SEPA ENVIRONMENTAL CHECKLIST

1. Name of proposed project, if applicable: [help]
Chimpanzee Sanctuary Expansion
2. Name of applicant: [help]
J.B. Mulcahy, Co-Director, Chimpanzee Sanctuary Northwest

12. Location of the proposal. Give sufficient information for a person to understand the precise location of your proposed project, including a street address, if any, and section, township, and range, if known. If a proposal would occur over a range of area, provide the range or boundaries of the site(s). Provide a legal description, site plan, vicinity map, and topographic map, if reasonably available. While you should submit any plans required by the agency, you are not required to duplicate maps or detailed plans submitted with any permit applications related to this checklist. [help]
25351 Hwy 10, Cle Elum, WA 98922, Parcel # 666734

SITE PLAN
SCALE 1" = 60'

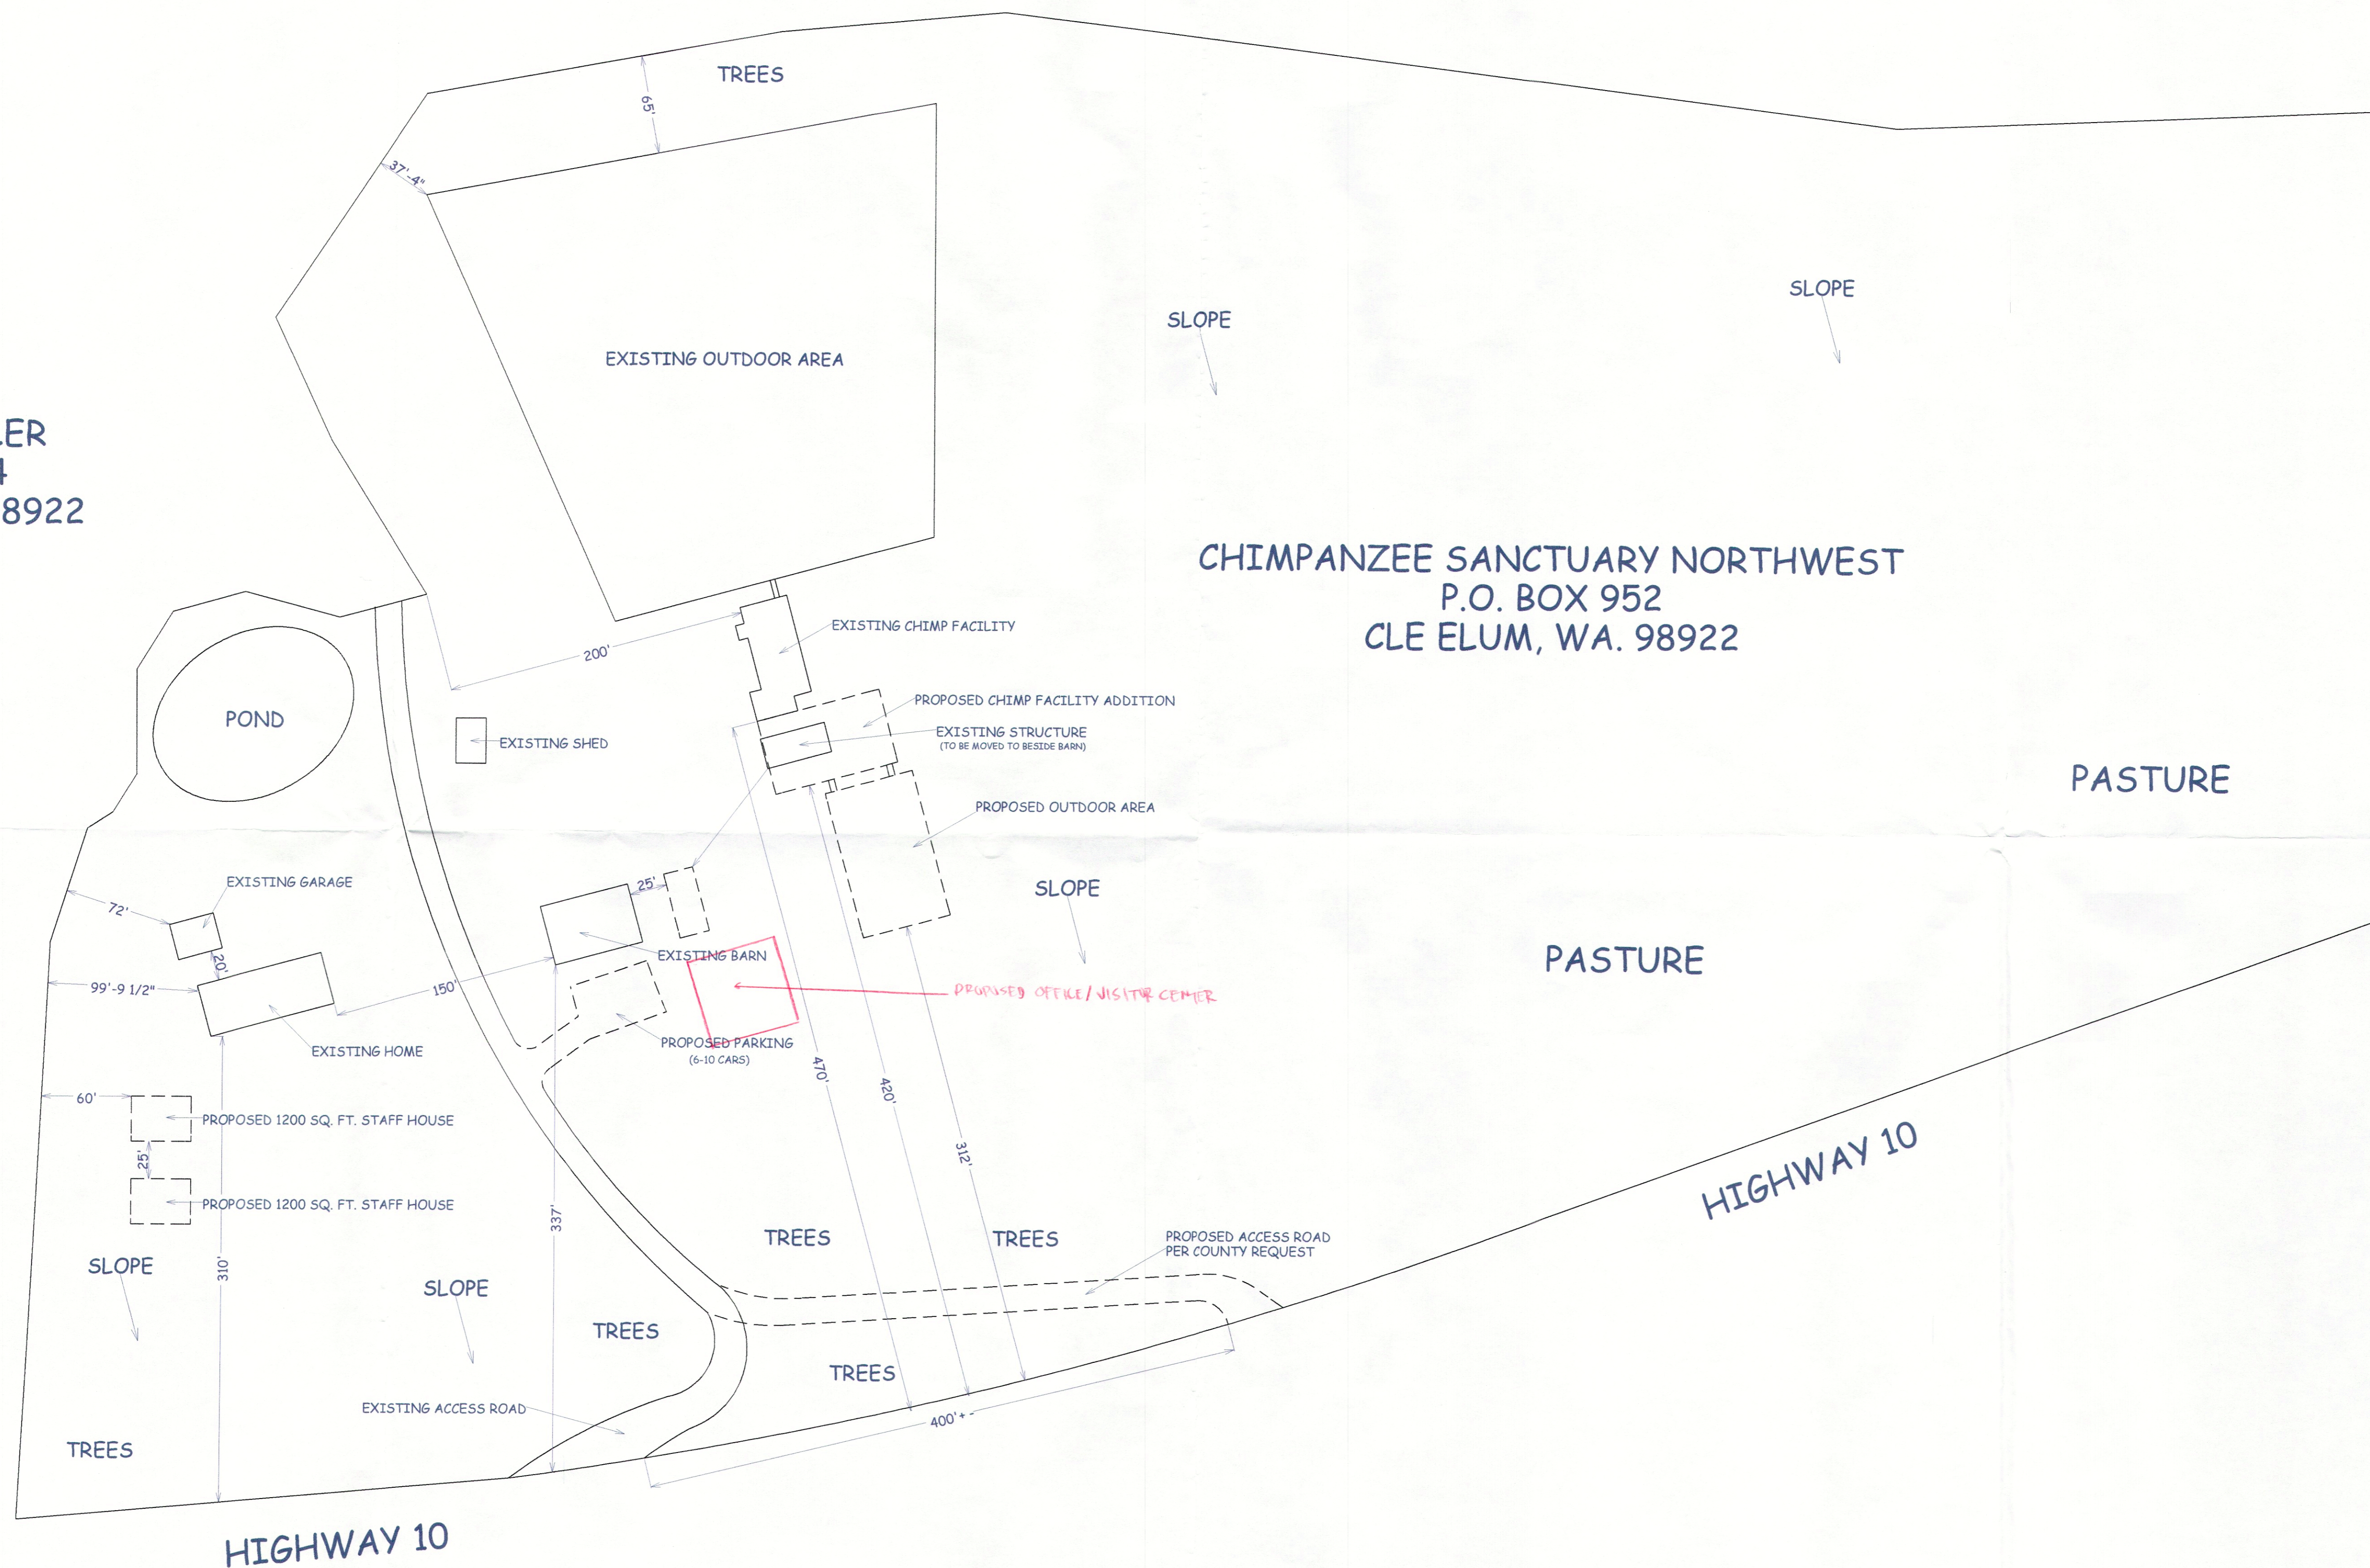
Site plans show
A Pond?
GIS indicates type
of Unknown
seems to go right
through construction
Area

Again check Stream -
